Cambridge Waste Water Treatment Plant Relocation Project
Anglian Water Services Limited

Traffic Flow Diagrams

Application Document Reference: 5.4.19.5

Our ref: **Additional Submissions**

2021 Base Year Traffic Flows AM (0800-0900)

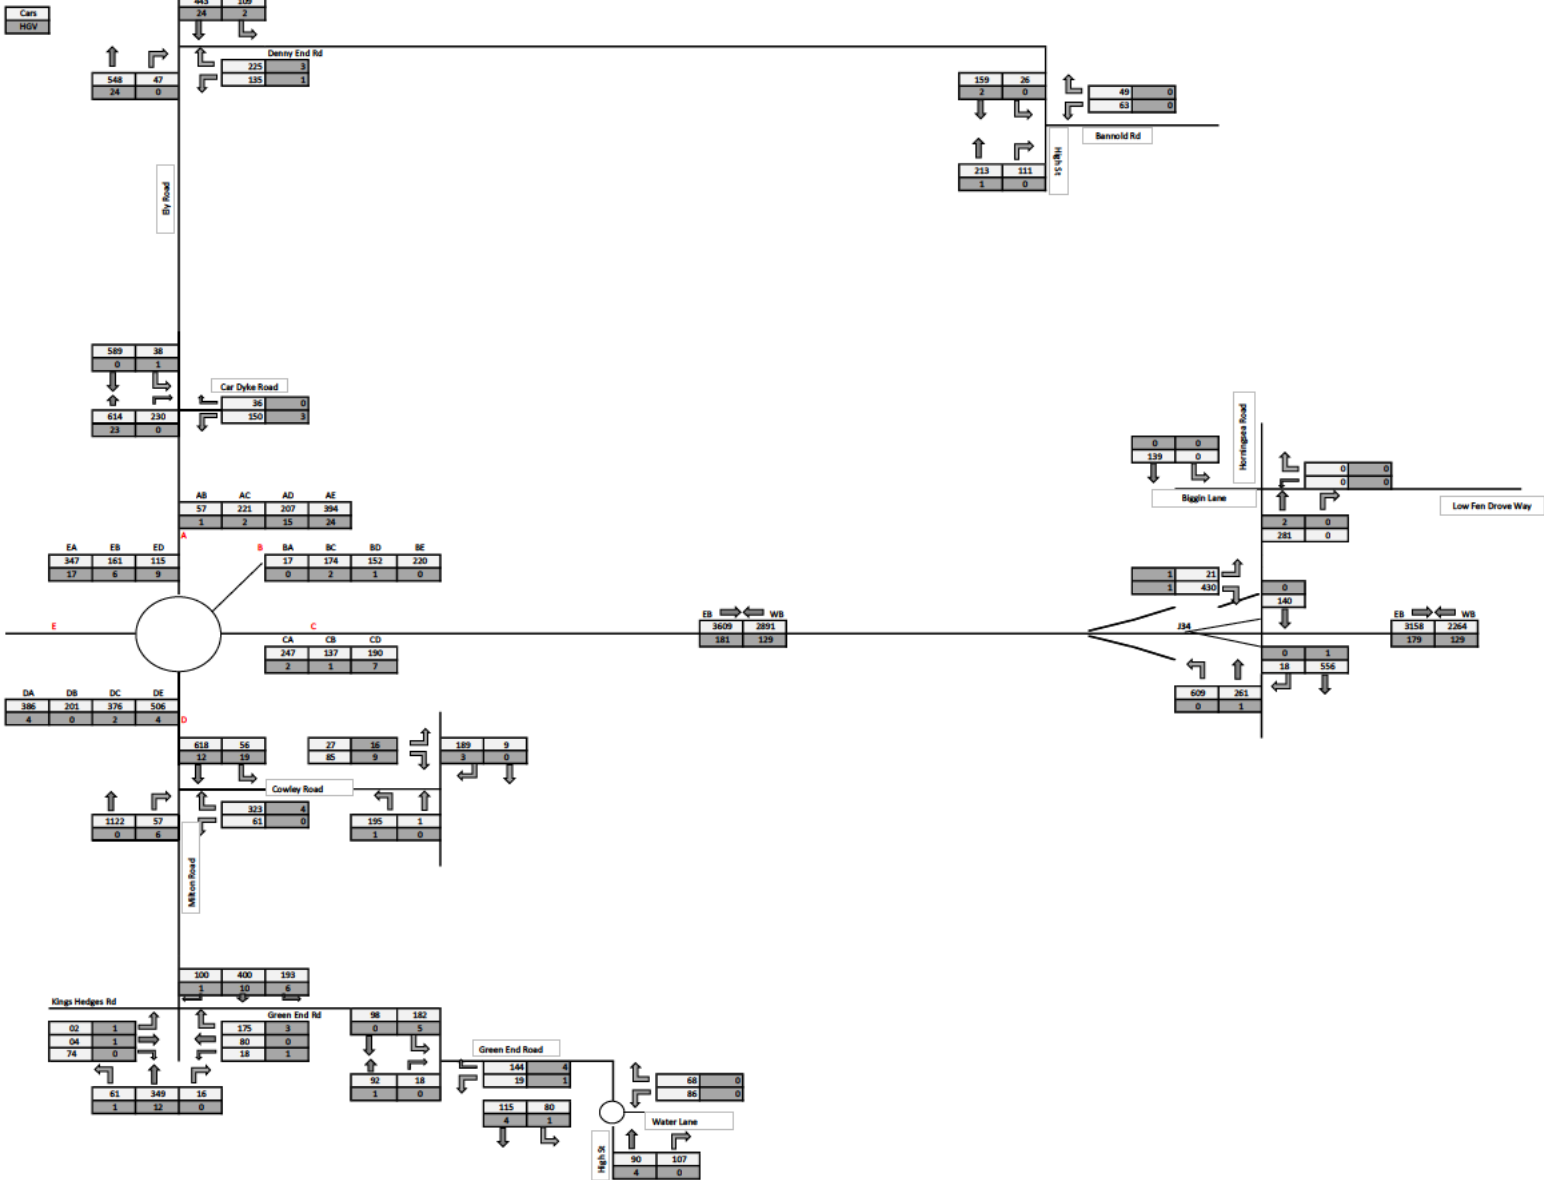
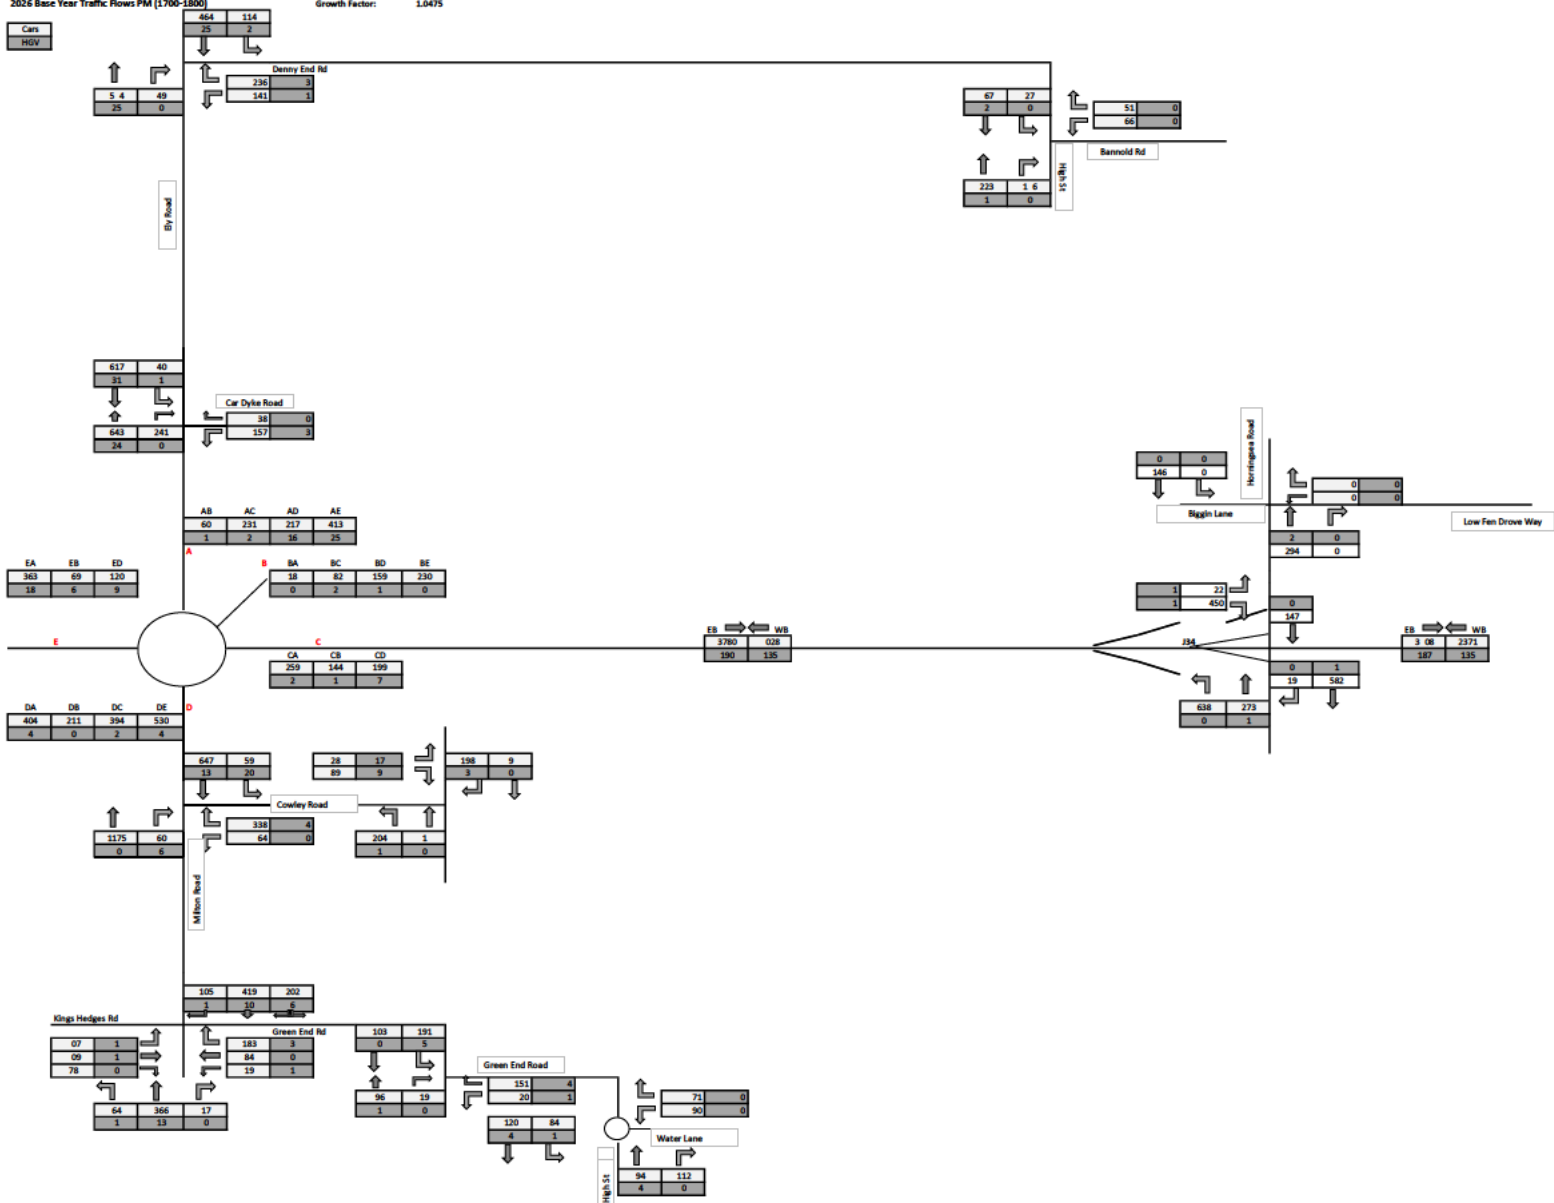
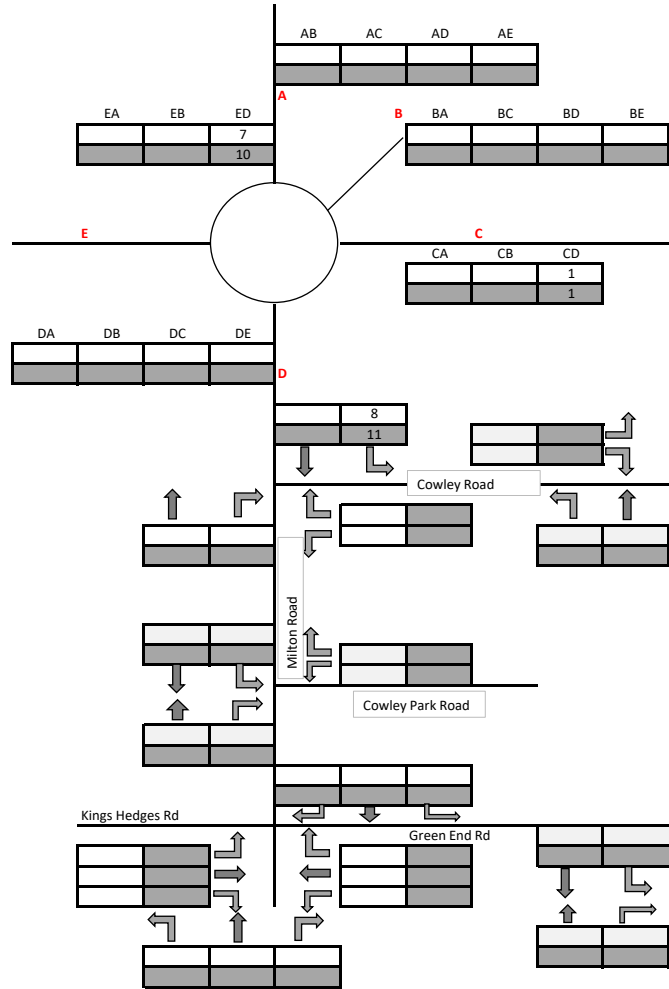
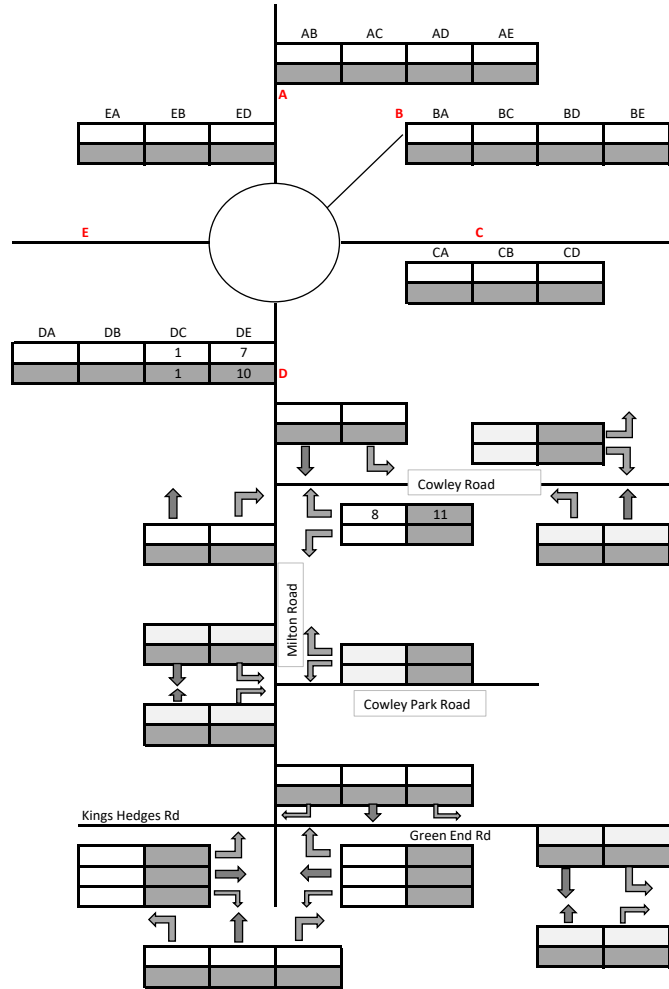
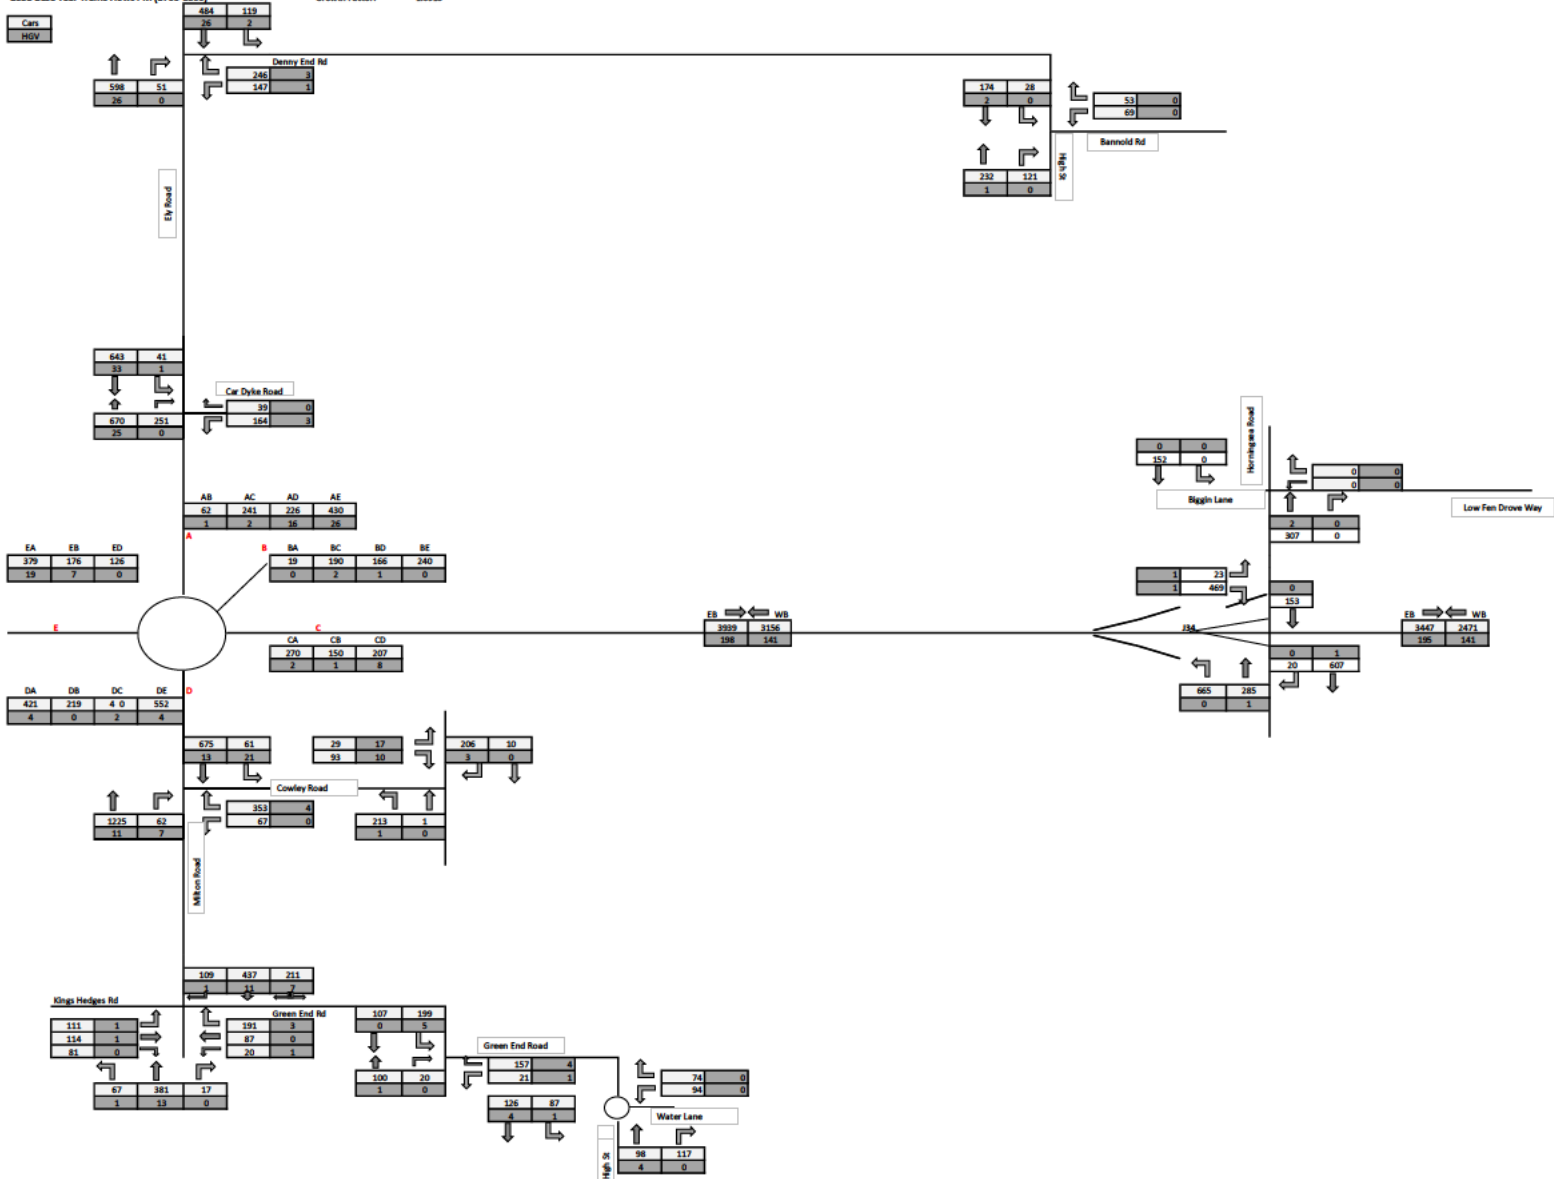
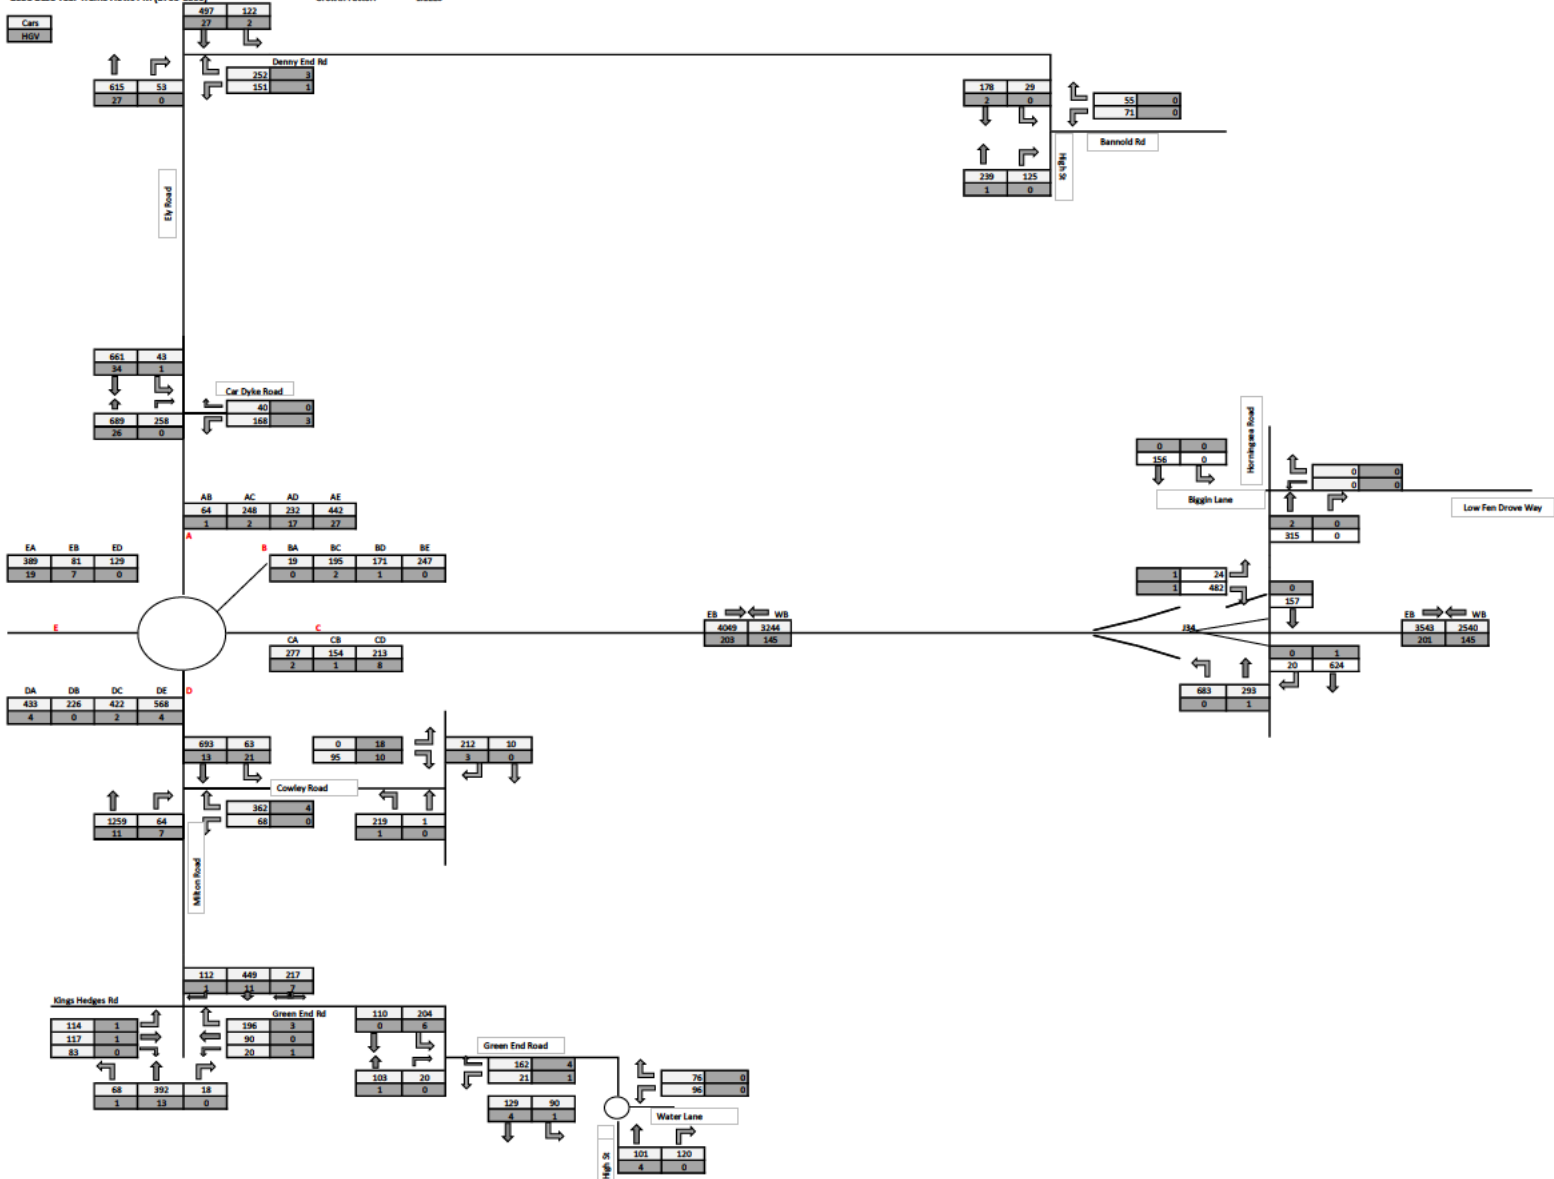
As set out in the Applicant's responses to ExA Hearing Actions from ISH3 [REP4-087], a review of the Transport Assessment and ES Chapter 19: Traffic and Transport and associated transport modelling and analysis has been carried out. This review has highlighted a number of issues, including an error that resulted in an over-estimation of background traffic flows, leading to an over-assessment of the level of congestion on affected junctions/road network. These issues have been addressed and the traffic flows and modelling updated accordingly. In addition, the operational traffic flows and traffic modelling have been amended to align with the revised parking provisions, updated for Deadline 4, which assume that all staff, visitor and operational car parking spaces are occupied in the peak hour as a reasonable worst case. As a result of these changes, 5.4.19.5 Traffic flow diagrams has been updated to reflect the revised traffic flows and 5.4.19.6 Junction capacity reports has been updated to reflect the revised junction modelling results.
